**PLAN REVIEW SHEET**

**Petition #: RZP 2021-186**

**Address: 9405 Mallard Creek Rd.**

**Request: R-8MF (CD)**

REZONING - SITE PLAN
THE VILLAGES AT GOVERNOR HUNT
 9405 MALLARD CREEK RD., CHARLOTTE, NC

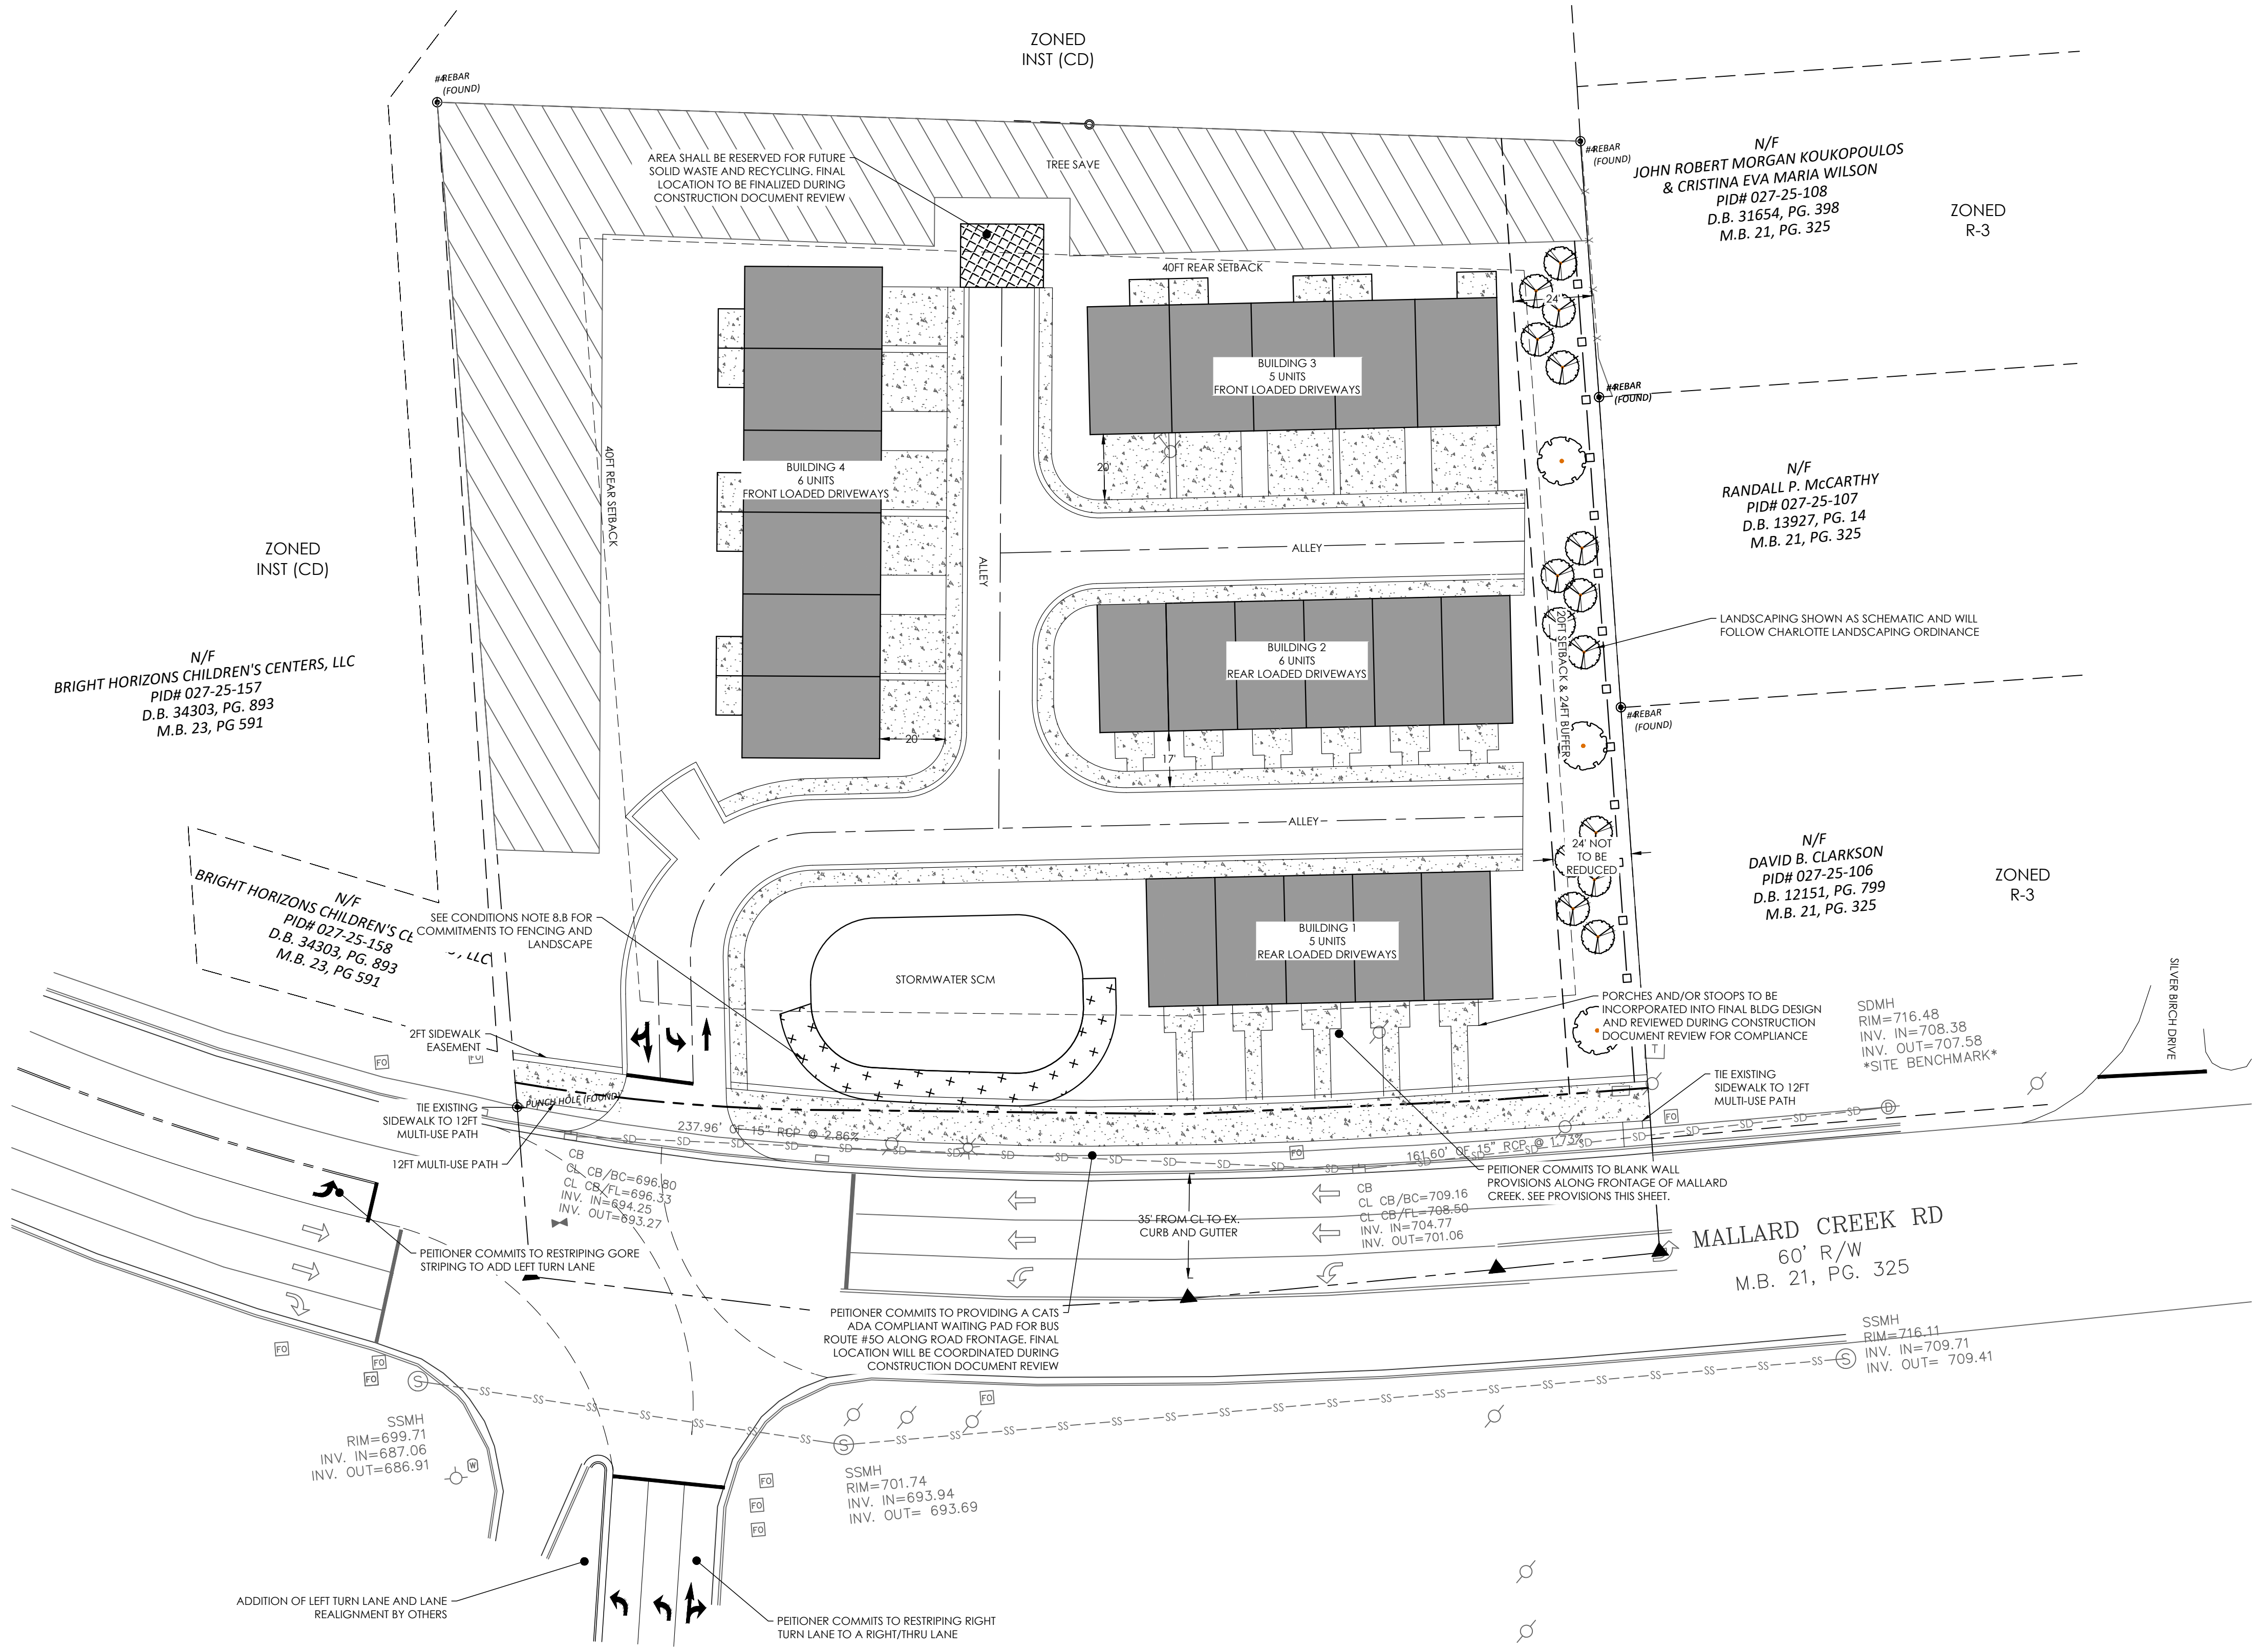
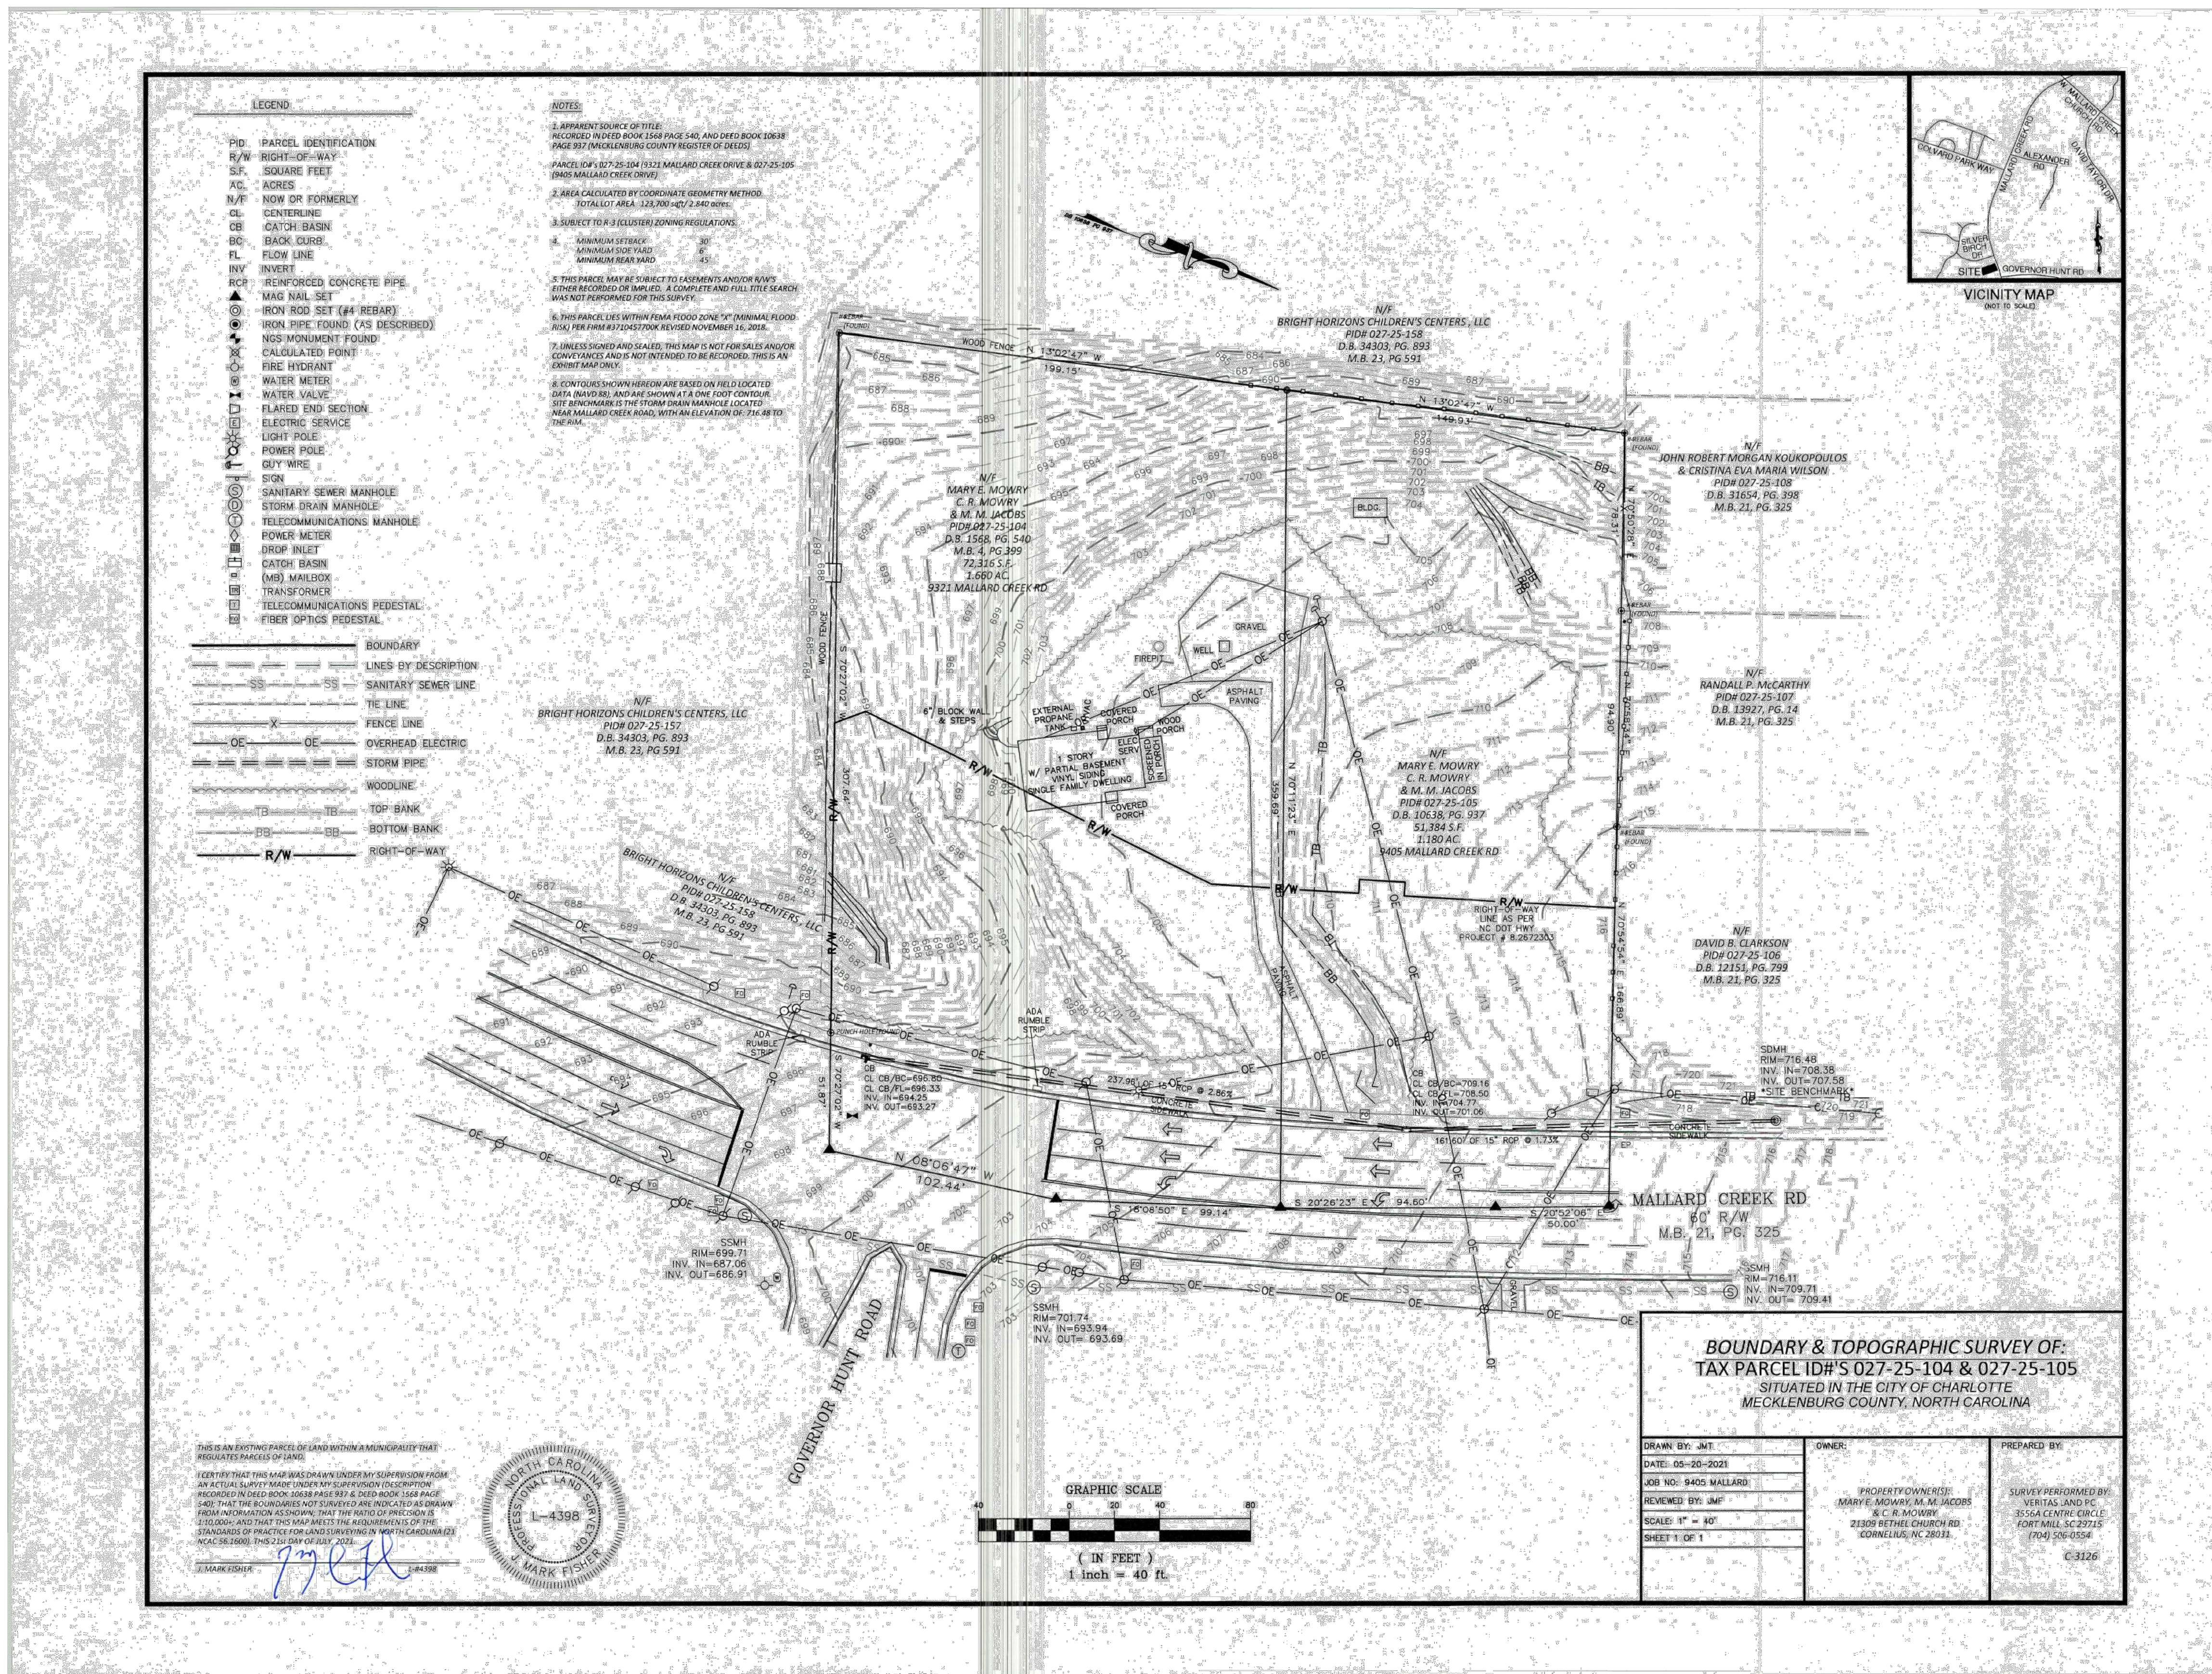
The site is located along CATS local bus route #50 on Mallard Creek Rd. CATS requests the construction of an ADA compliant waiting pad per Land Development Standard 60.01B on Mallard Creek Rd. The final location of the pad will be coordinated with the developer through the permitting process.
